Arun District Council
Arun Civic Centre
Maltravers Road
Littlehampton
West Sussex BN17 5LF
Planning & Building Control General Enquiries
Tel: (01903) 737756 Fax: (01903) 730442
Dx: 57406 Littlehampton
Minicom: 01903 732765
e-mail: planning@arun.gov.uk
website: www.arun.gov.uk/planning

Application No: WA/63/21/PL
Site Address: Land East of Tye Lane Walberton BN18 0LU
Description of works: Proposed alternative vehicular accesses off Tye Lane and emergency access off Avisford Park Road, along with minor highway works following WA/95/18/RES (resubmission following WA/93/20/PL). This site is CIL Zone 2 (Zero Rated) as other development.

Thank you for your internet representation made on 5th August 2021 which has been recorded as an objection with the comments as follows:

Drawing Title:
PROPOSED ALTERNATIVE ACCESS

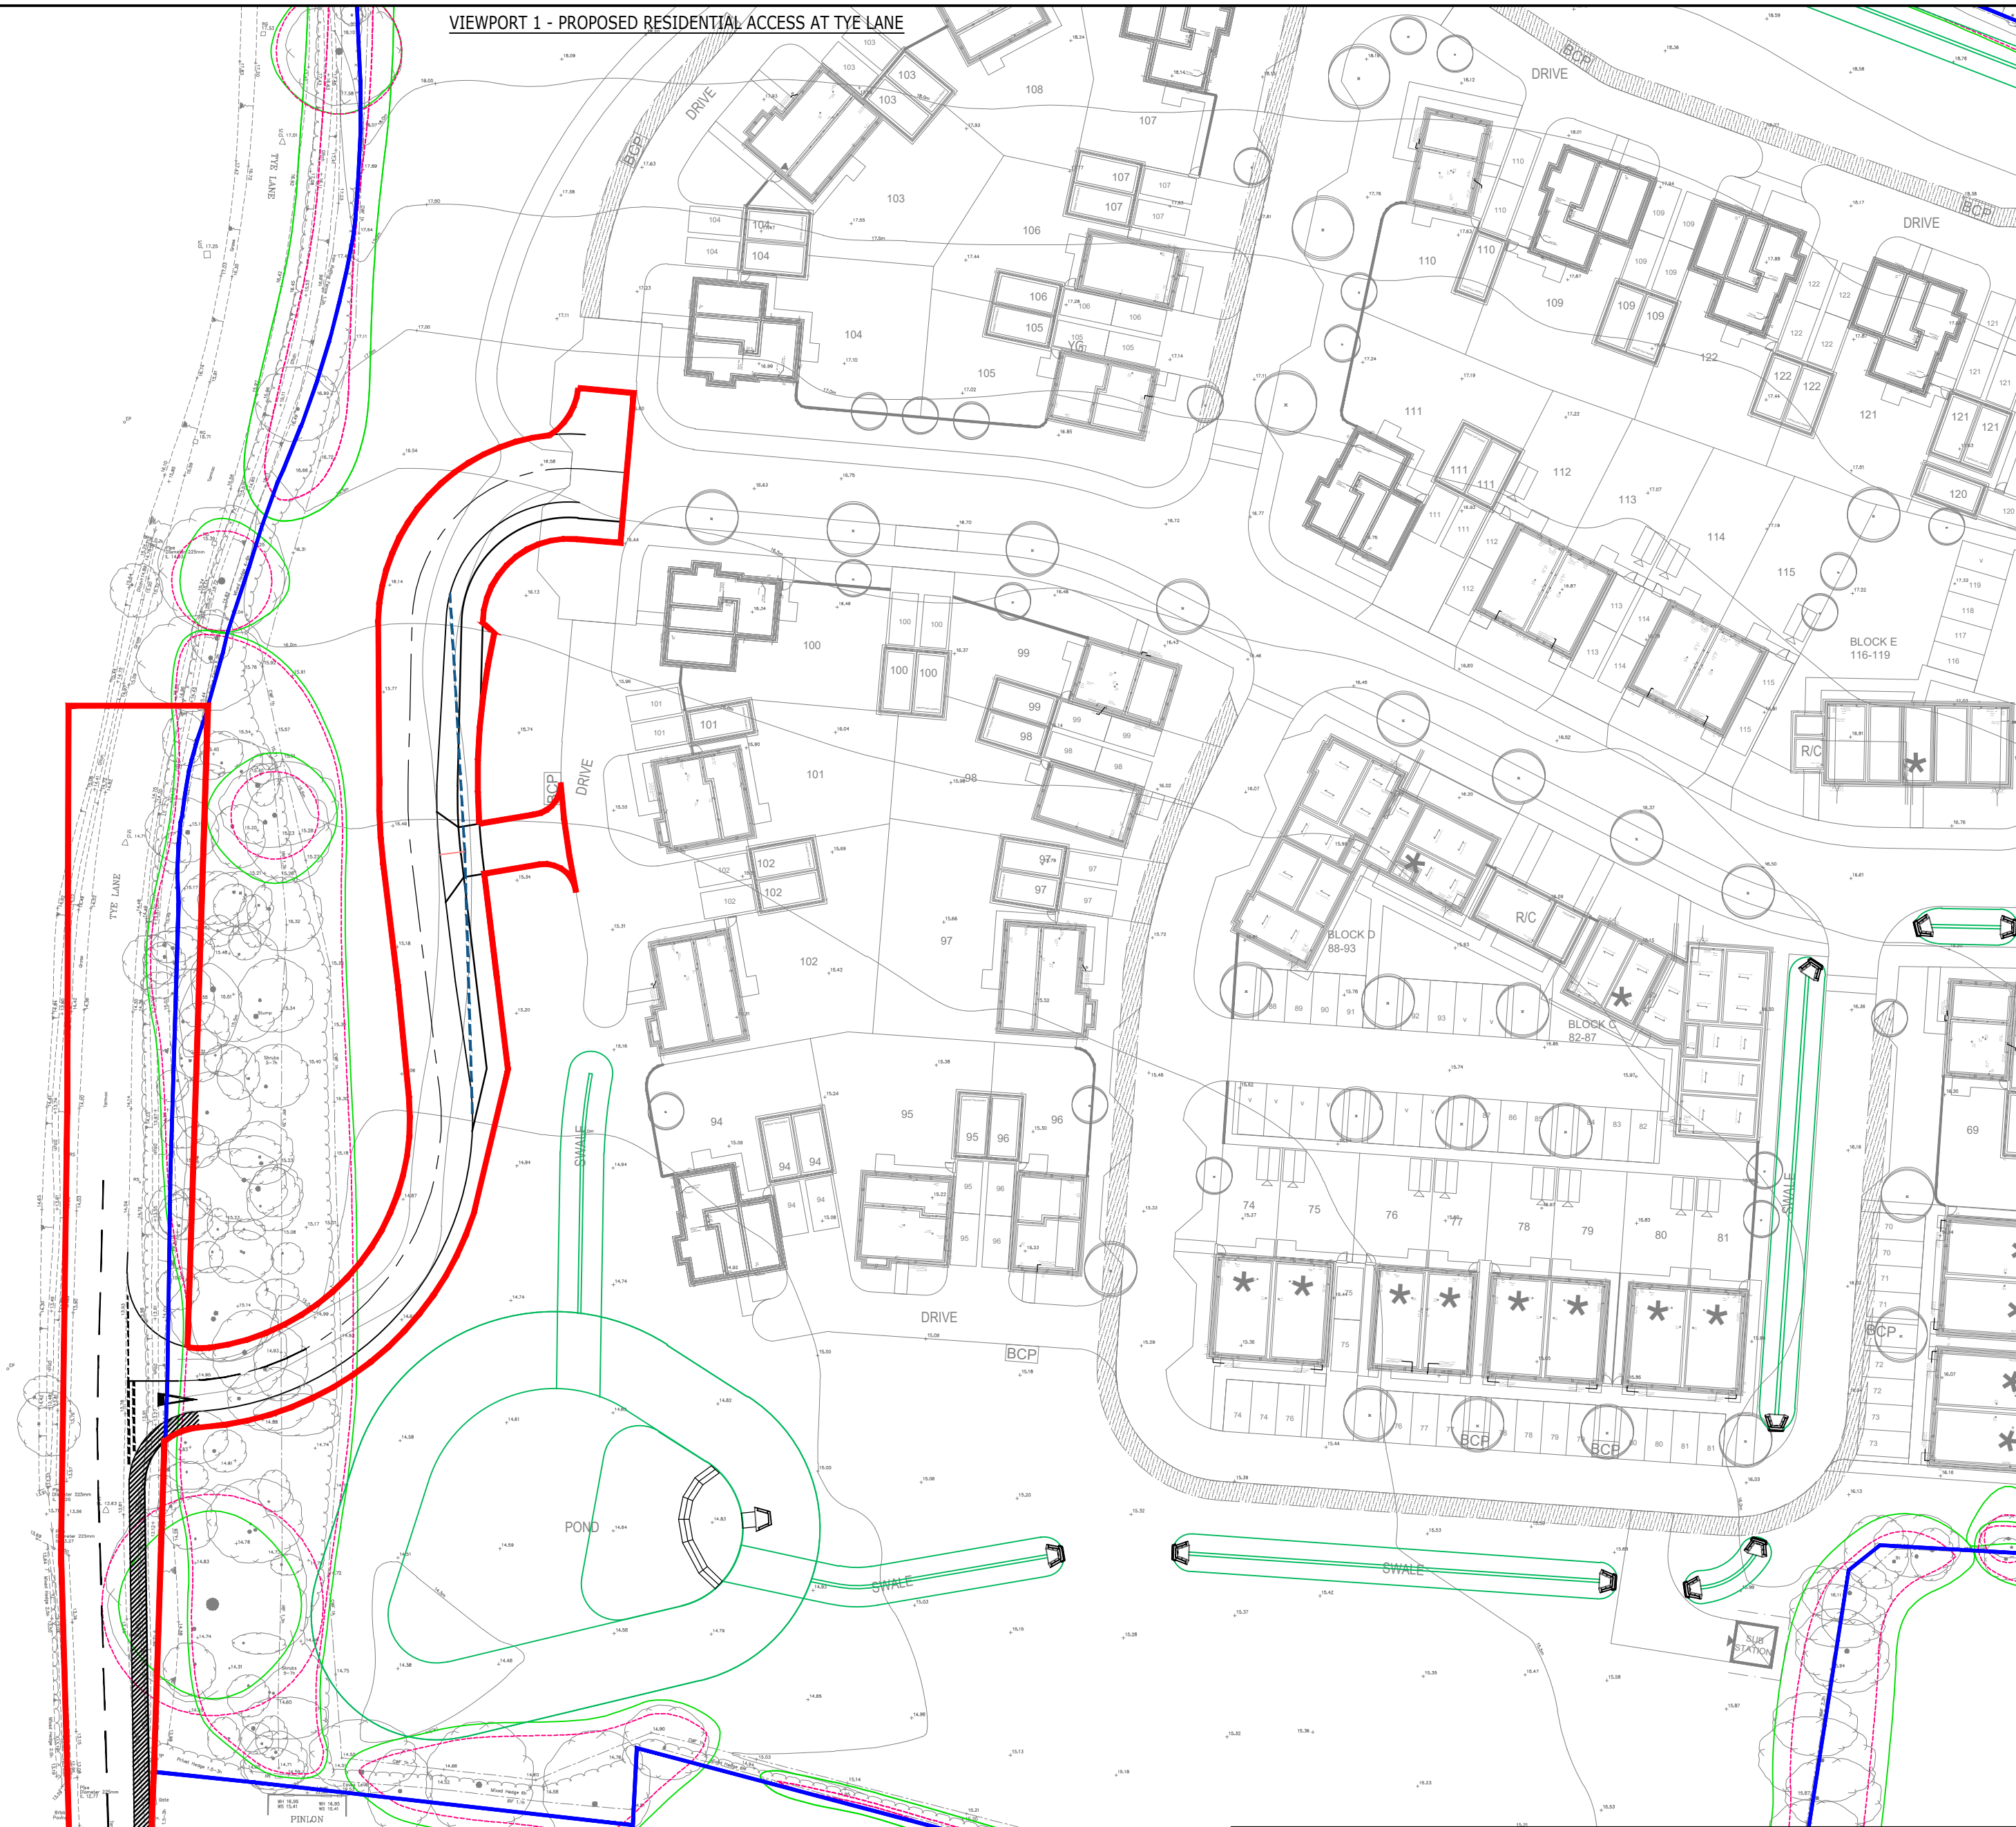
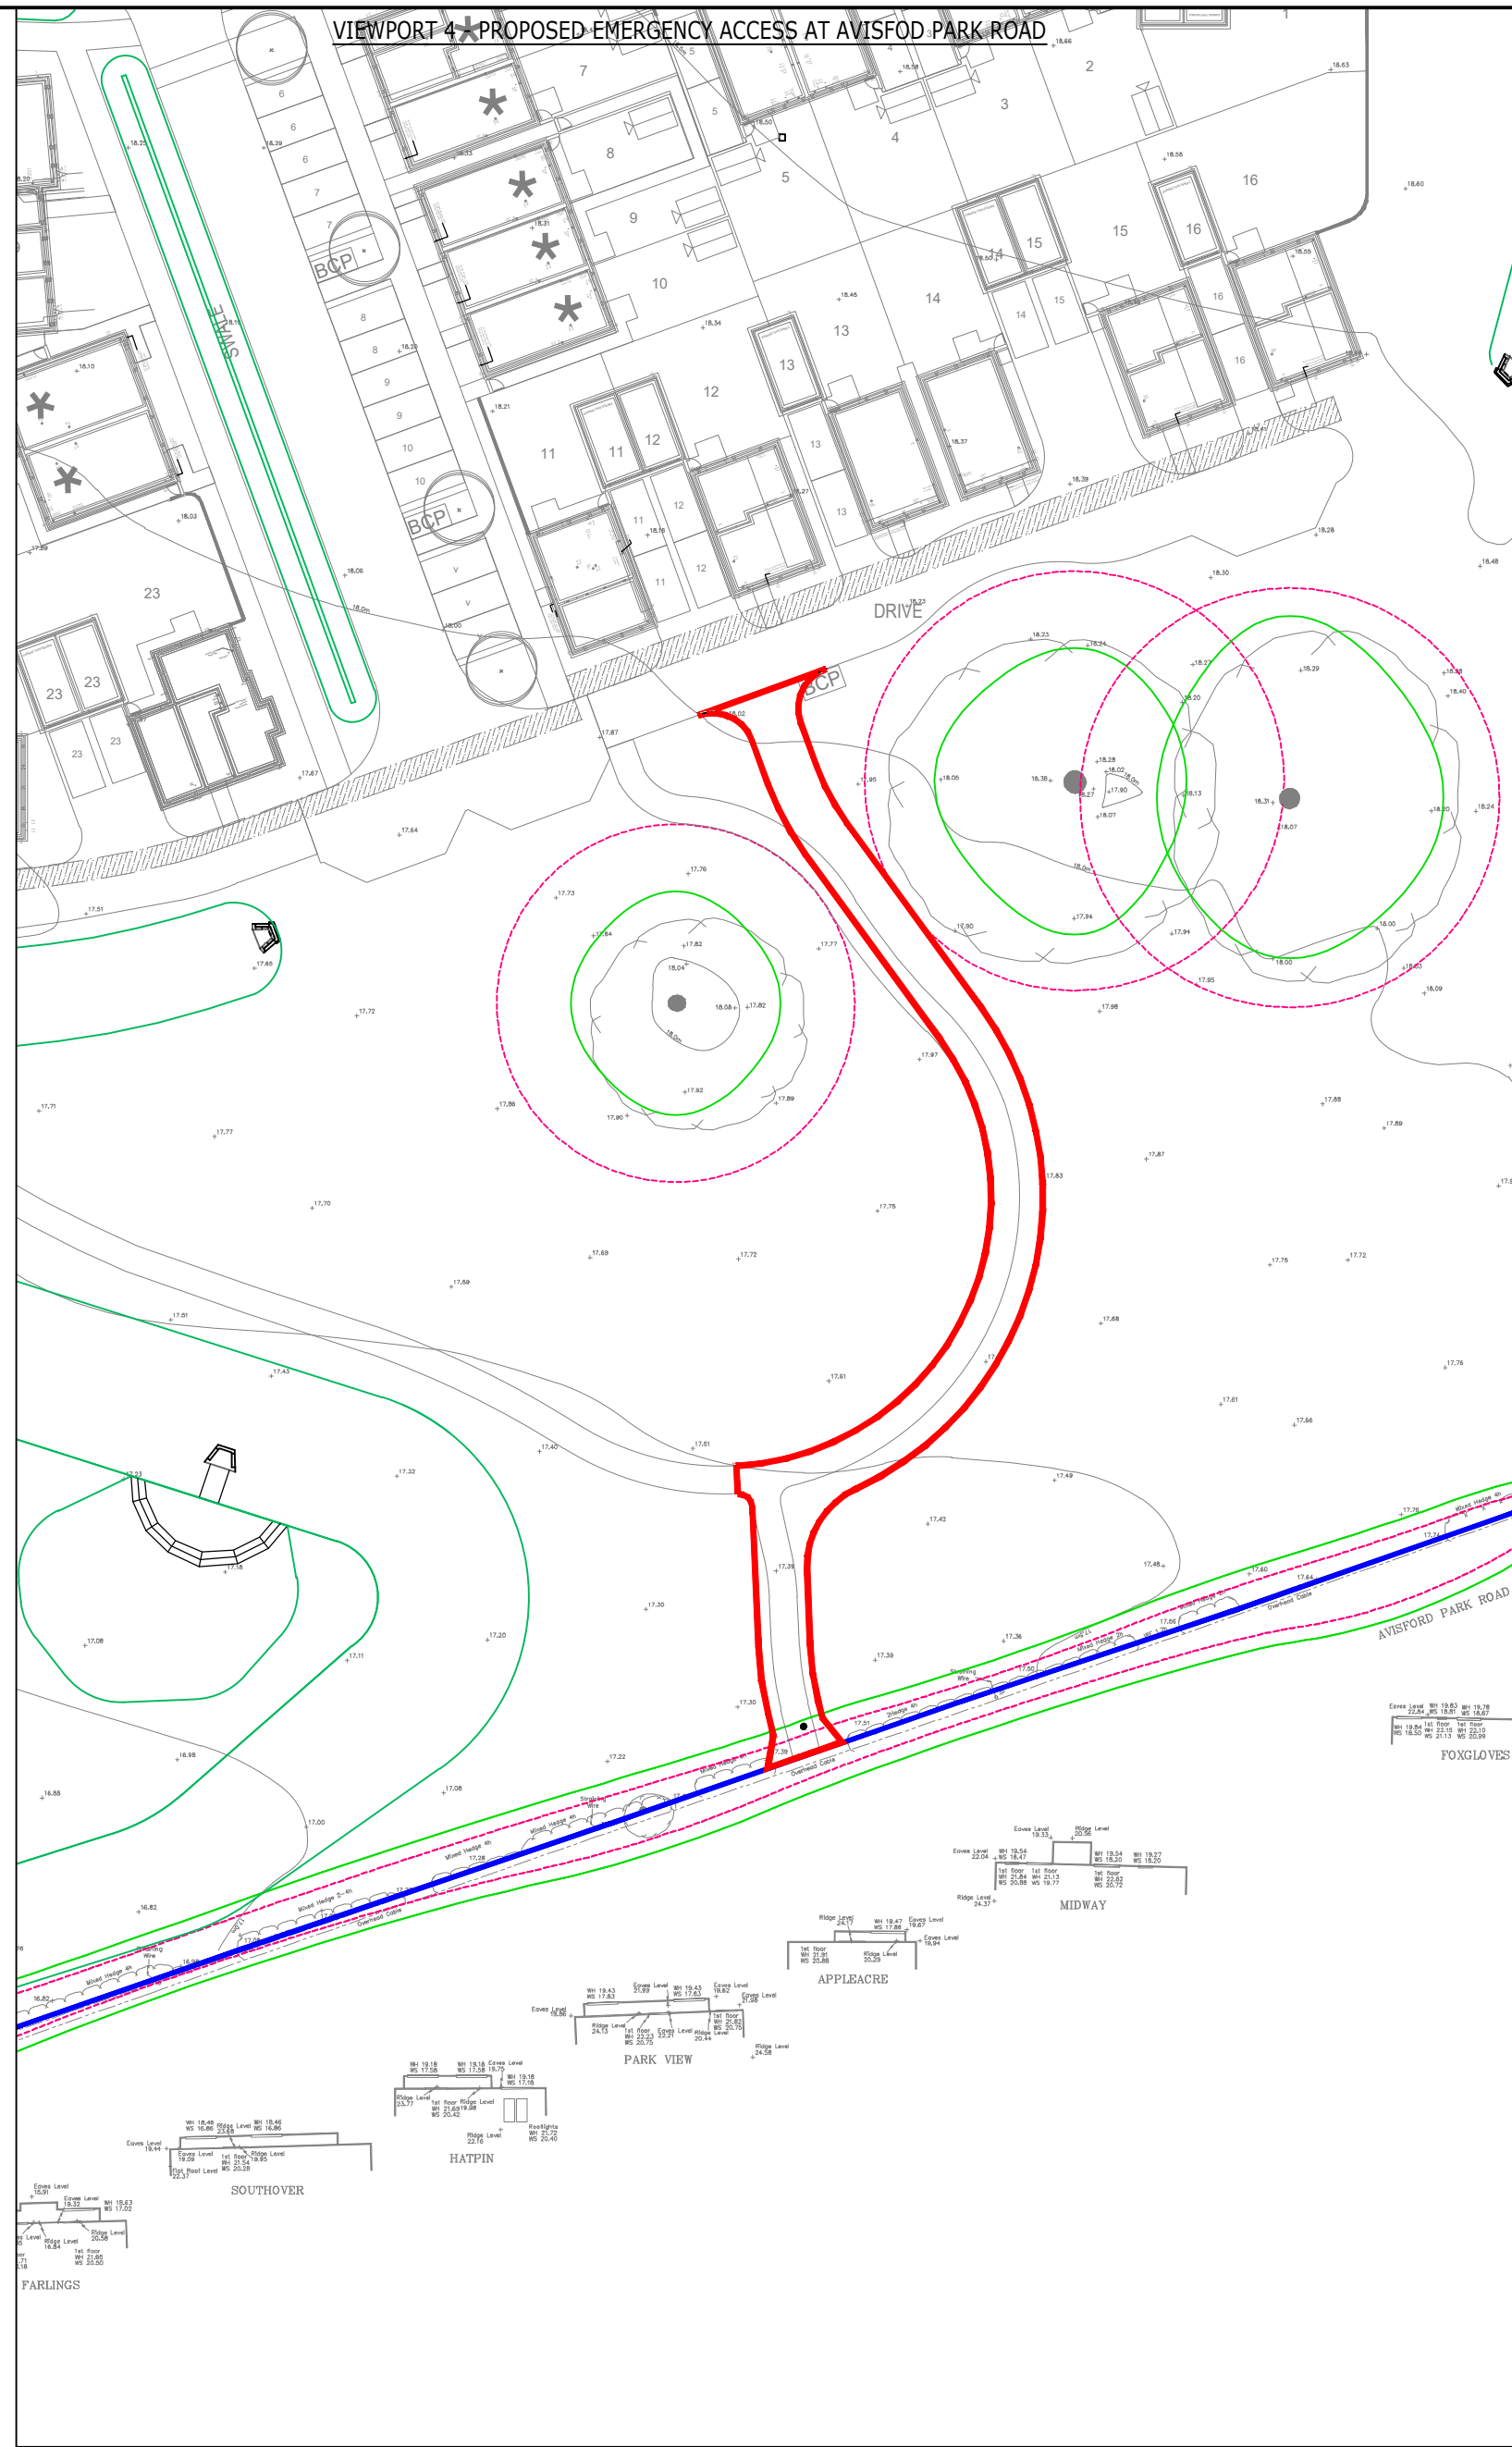
The Avisford Park Road emergency access is inappropriate. The developer has a plan showing a fire vehicle proceeding up the Twitten from the Street to Avisford Park Road, the width of which will just accommodate a wheelchair. WSCC, as the owner of this twitten has not commented.
